<b>Application Ref:</b>	3/2016/0315 (LBC) & 0316 (PA)	 <p>Ribble Valley Borough Council <a href="http://www.ribblevalley.gov.uk">www.ribblevalley.gov.uk</a></p>
<b>Date Inspected:</b>	22/01/16	
<b>Officer:</b>	AD	
<b>DELEGATED ITEM FILE REPORT:</b>		<b>REFUSAL</b>

<b>Development Description:</b>	Proposed alterations, extension and repairs.
<b>Site Address/Location:</b>	Fields Farm Sawley Road Grindleton BB7 4QS

Existing Floor Plans

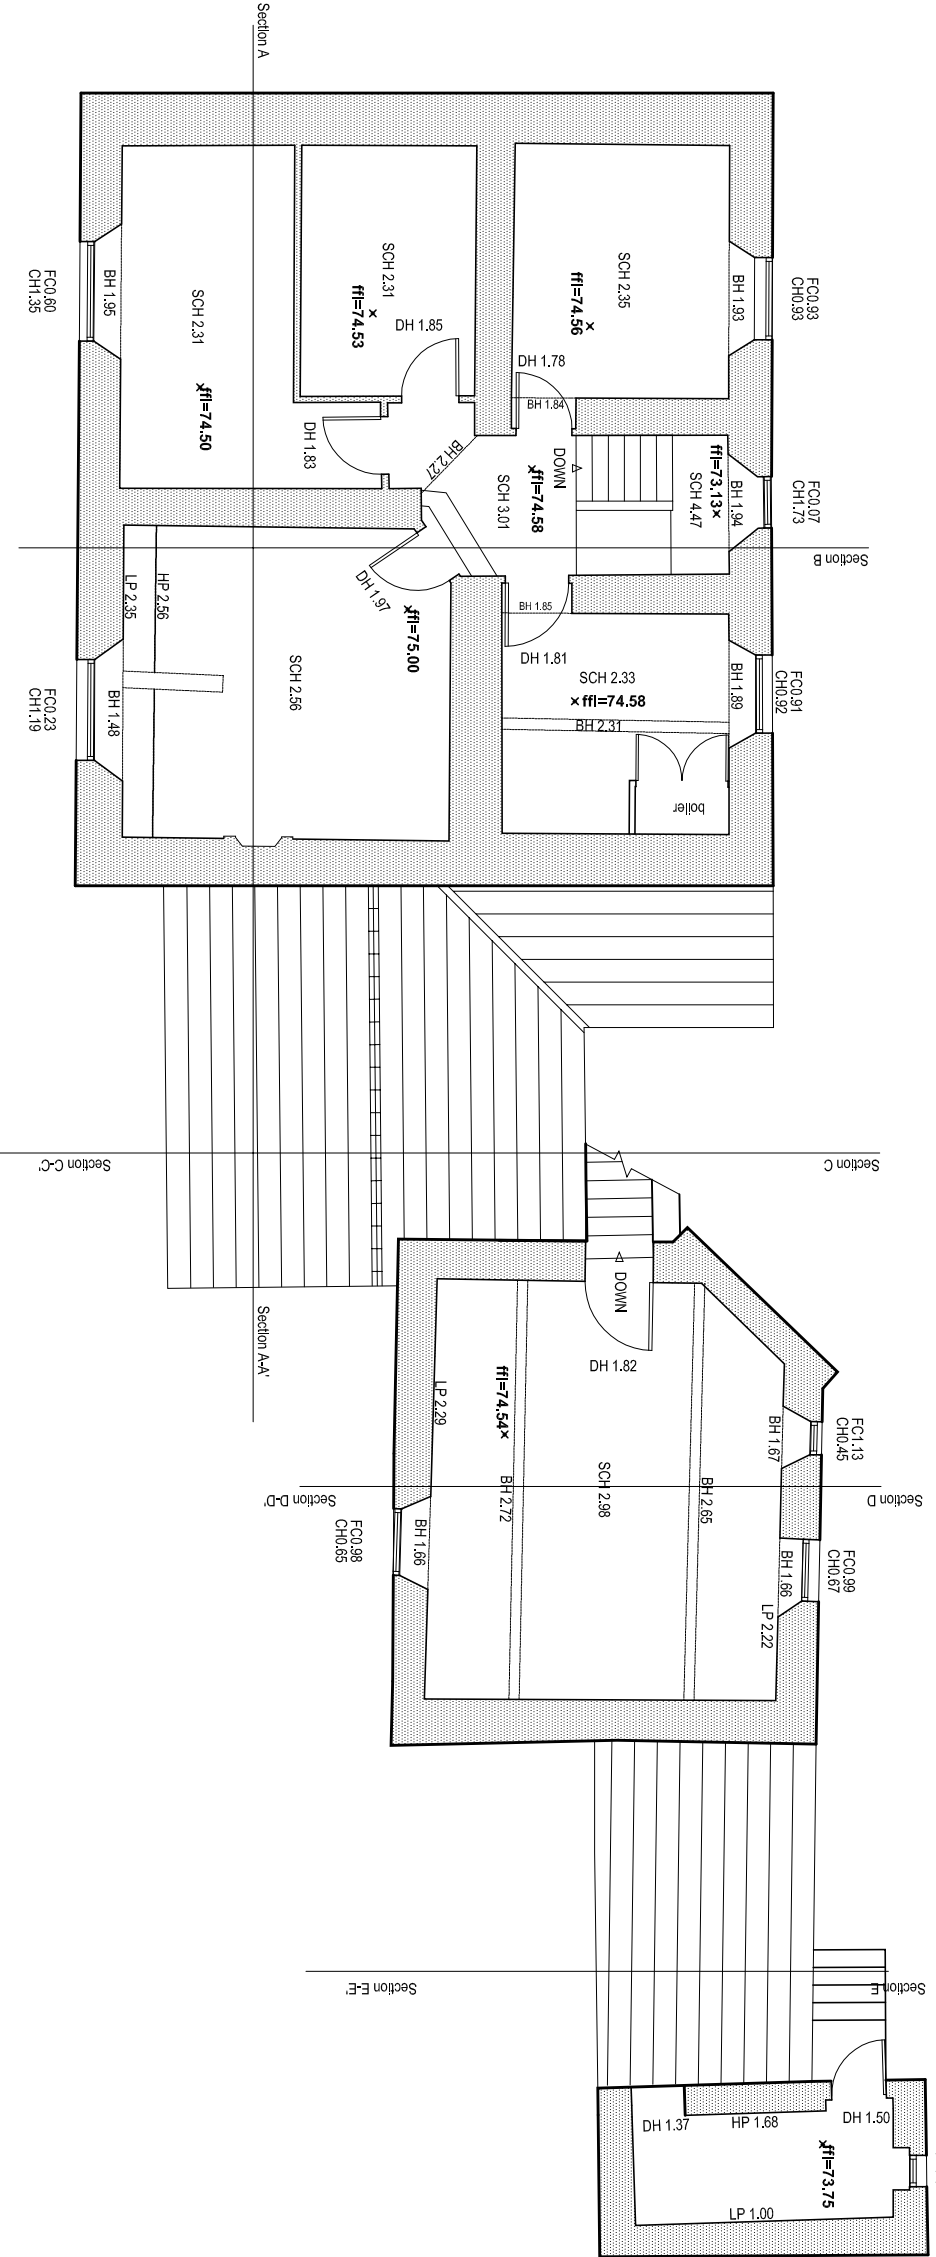
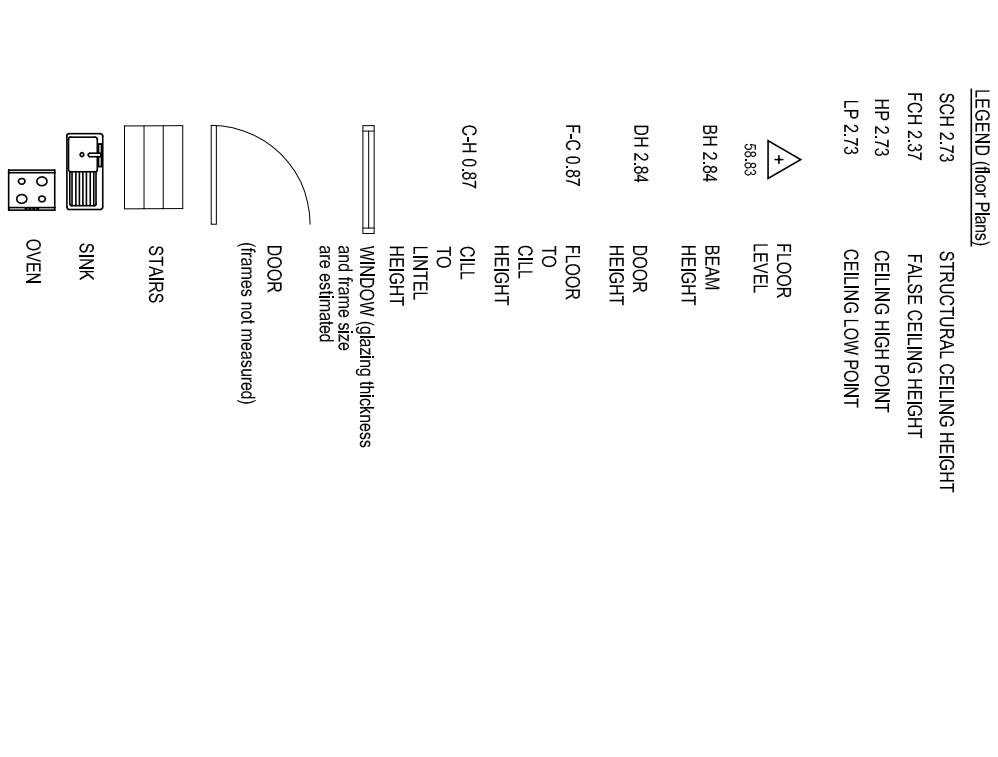
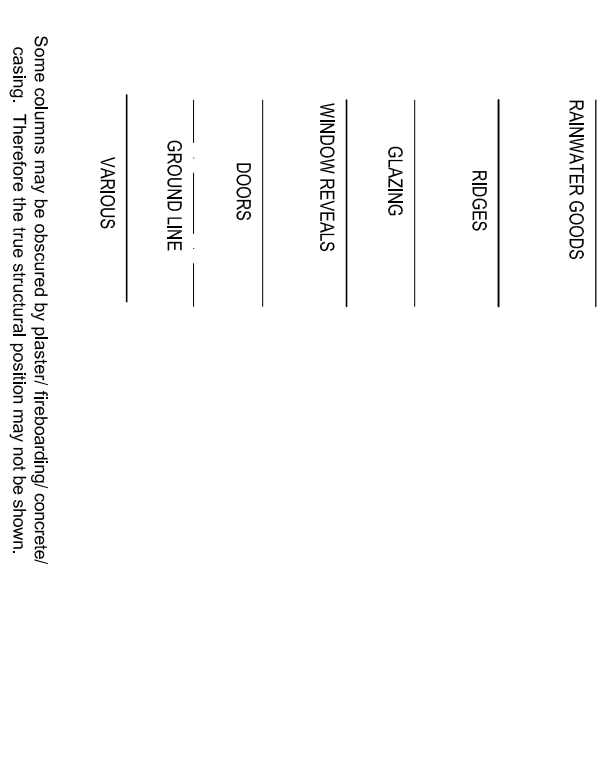
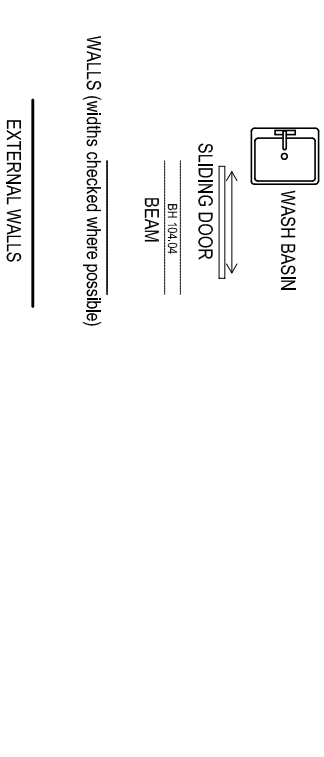
- (ii) Stephen Haigh (paragraph 6.6) identifies the historic plan form of the house to be amongst the most significant features of the listed building. Furthermore, whilst the first floor is wholly modern in appearance the main room divisions have been preserved (paragraph 5.6). In my opinion, the proposed openings between first floor proposed bedrooms and bathrooms is harmful to the special architectural and historic interest of the listed building and is not clearly and convincingly justified (NPPF Paragraph 132);
